Additional representation in respect of the Bramford to Twinstead Project submitted by Pebmarsh Parish Council

National Grids proposal for the haul road from the A131 to the cable sealing end compound have been under researched and we are hugely concerned and unaware of how it will impact our village and at what environmental cost.

TITLE  
 2.11.8 DESIGN AND LAYOUT PLANS: STOUR VALLEY WEST CABLE SEALING END COMPOUND

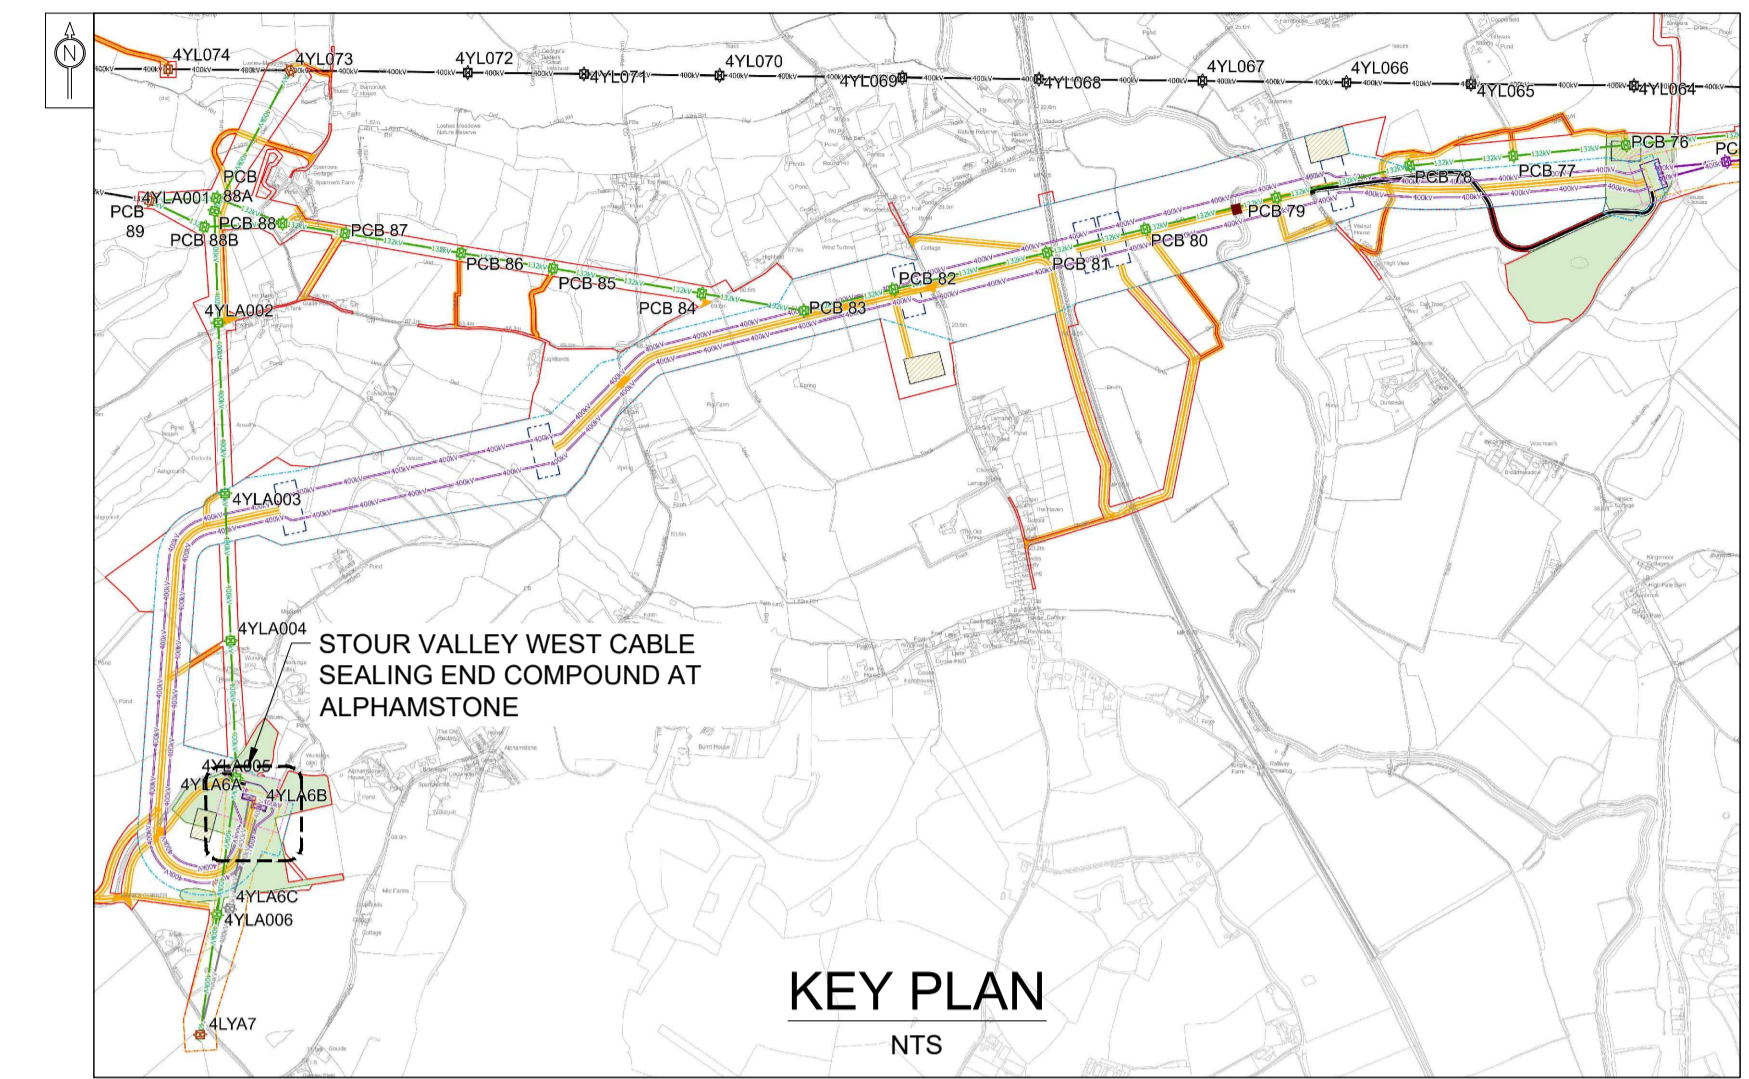
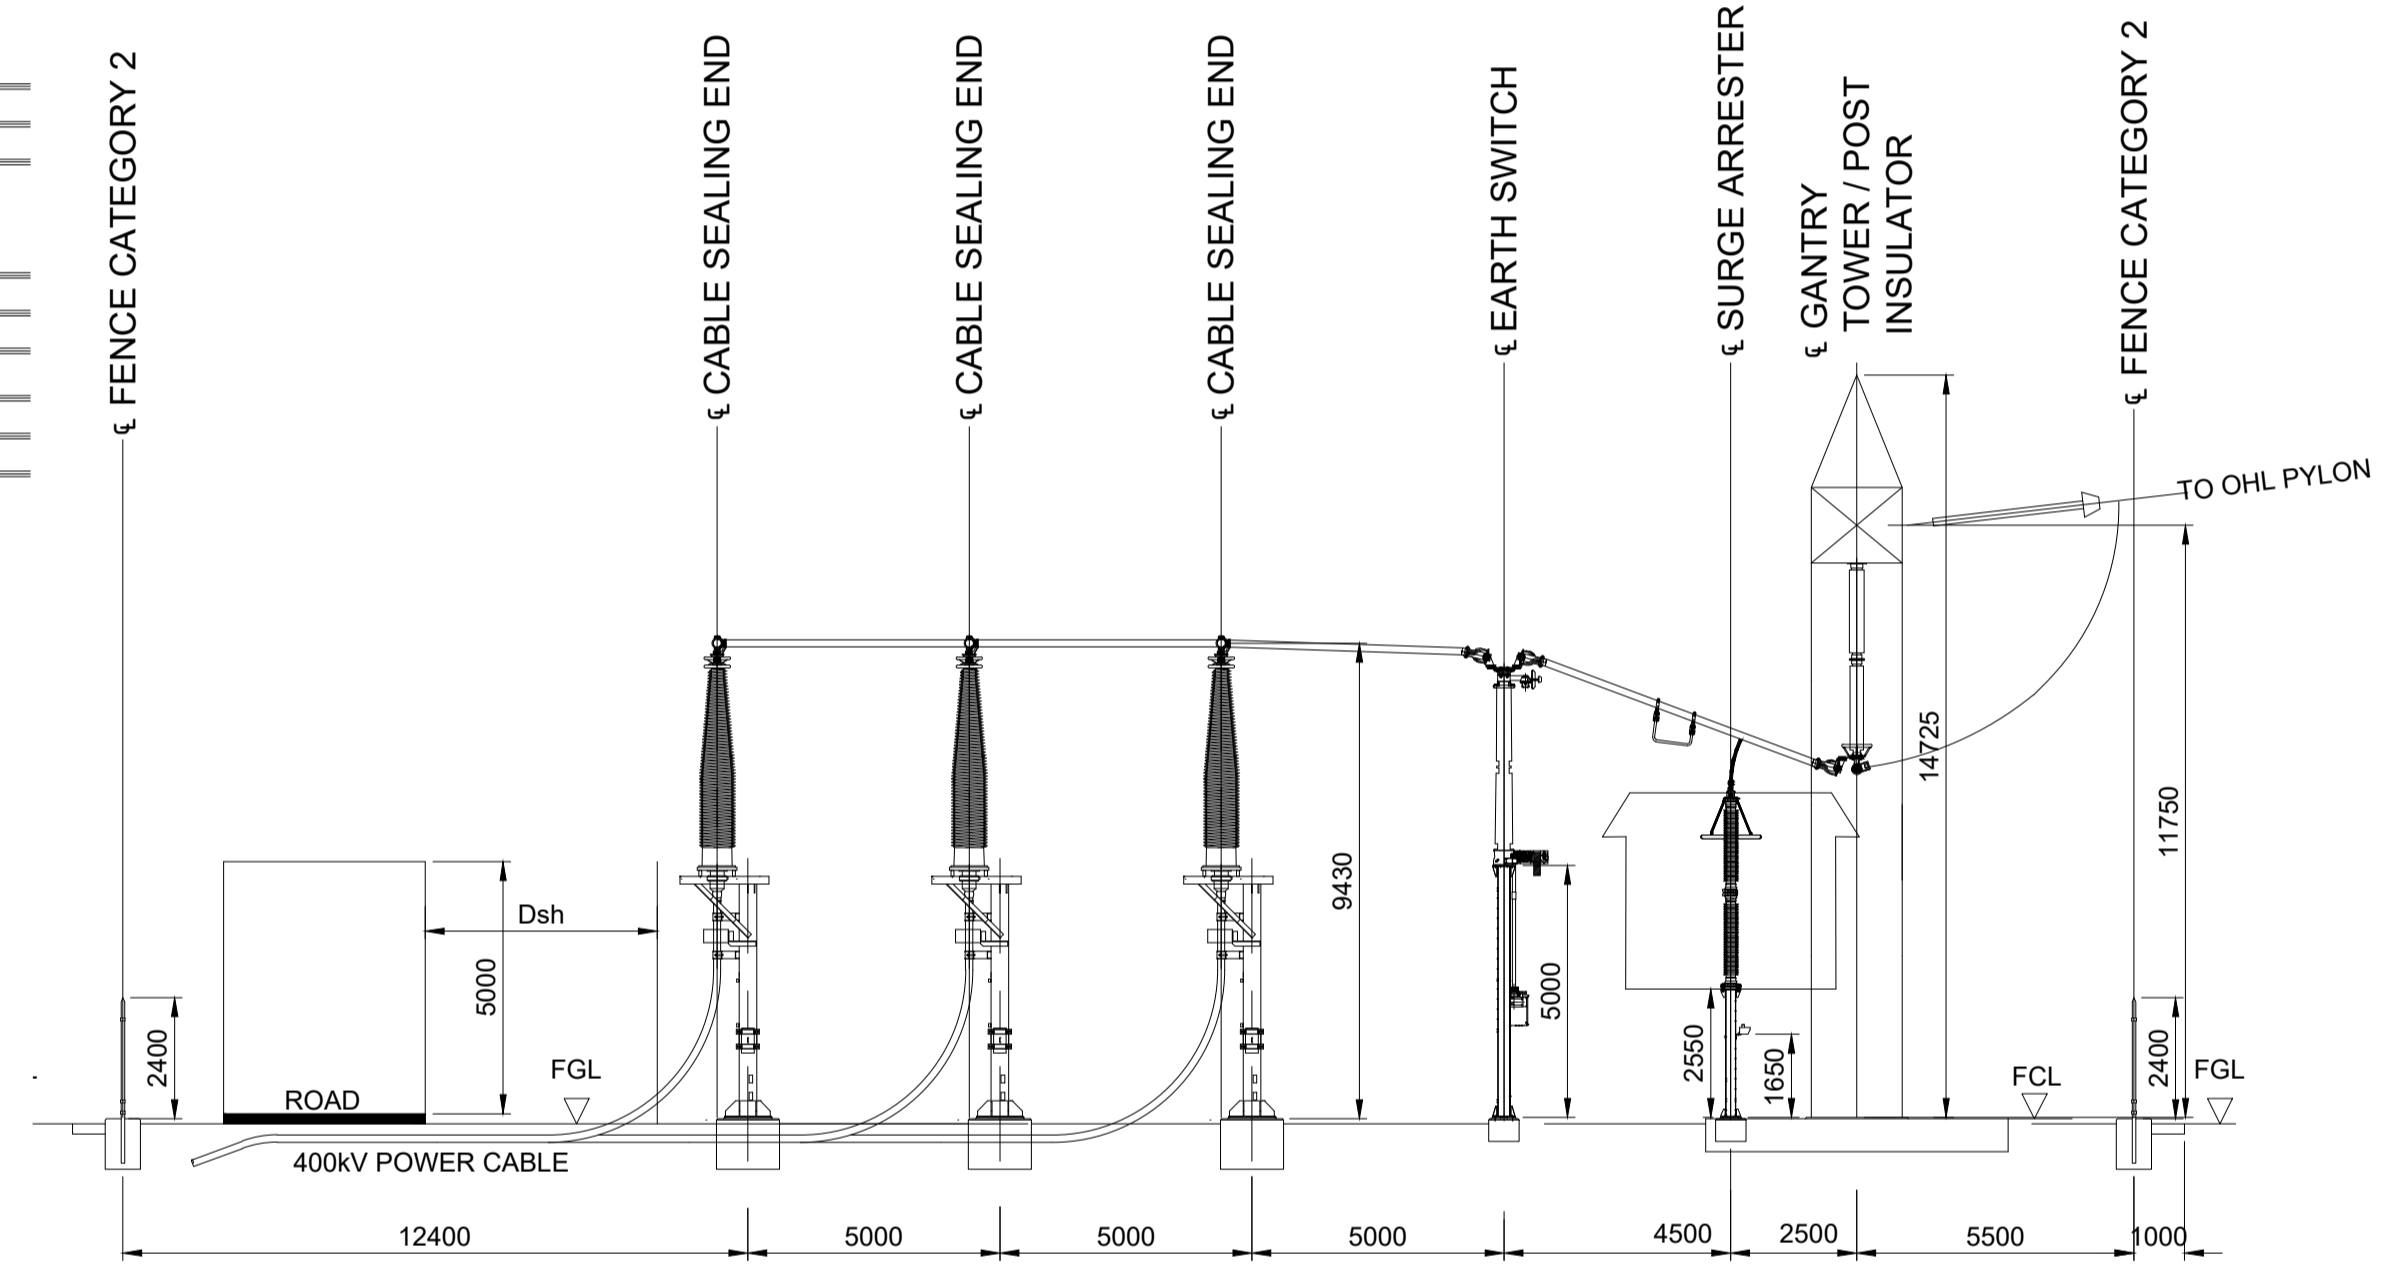
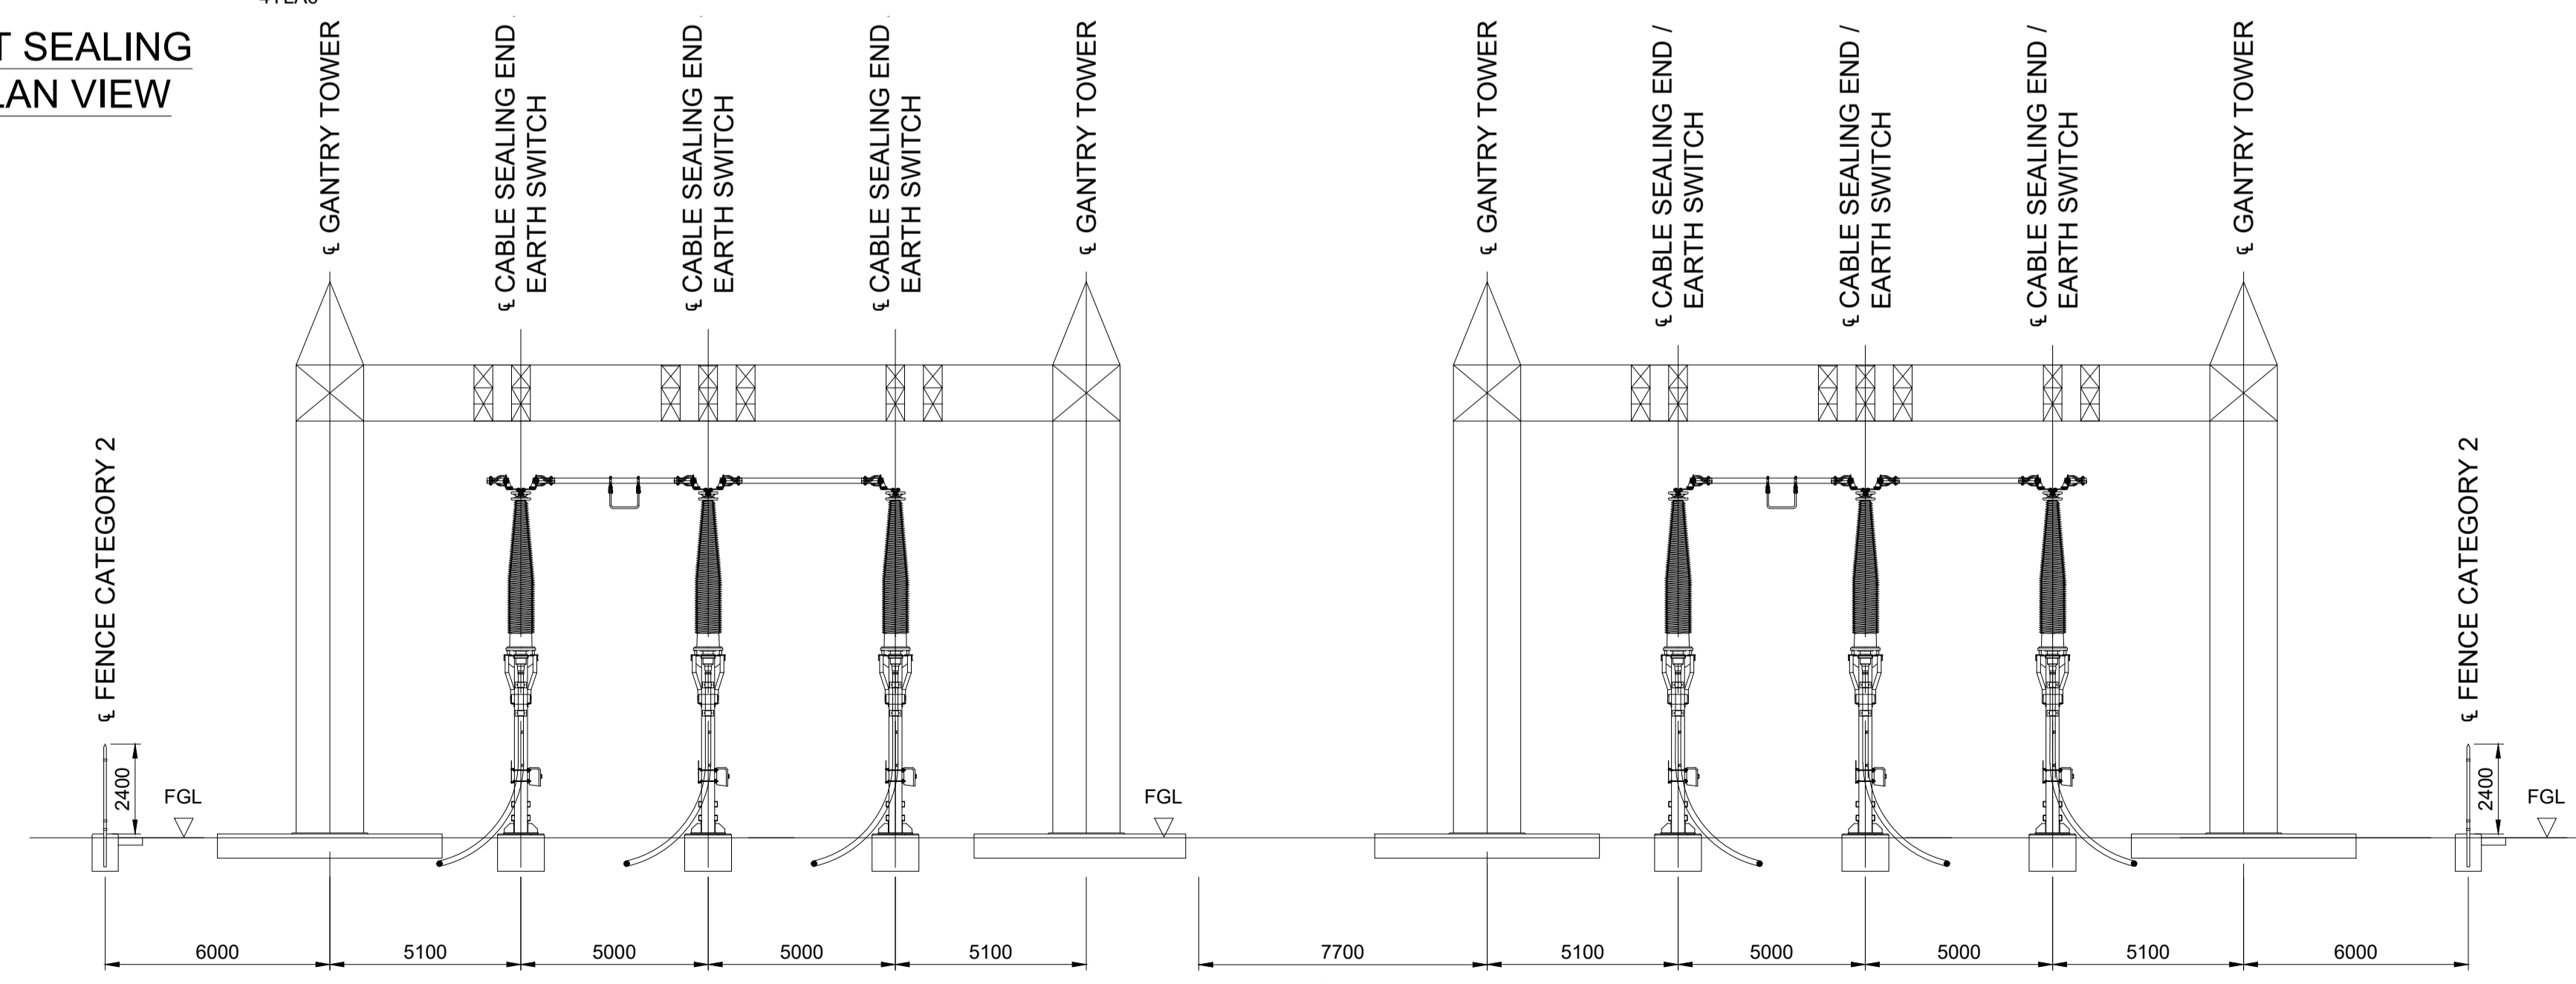
Essex Highways should be requested to survey the suitability of using some or all of the road network, we should not be reliant on NGs own consultant's report. We strongly believe that a hybrid approach to part road, part haul road would be less disruptive/destructive to our village. This could easily be achieved with careful traffic management and additional passing places, we would welcome a site inspection to view the options.

Have NG explored, evaluated, and shown evidence that the proposed haul road route is the best option?

Are NG requiring temporary or permanent access rights over agricultural land and what are the long-term implications? We were not aware of this change in requirements during the consultation period.

How is the haul road constructed and at what width?

How much traffic will be going to the sealing end compound and what quantity of additional traffic is required for the construction of the haul road?

How will the haul road be policed?
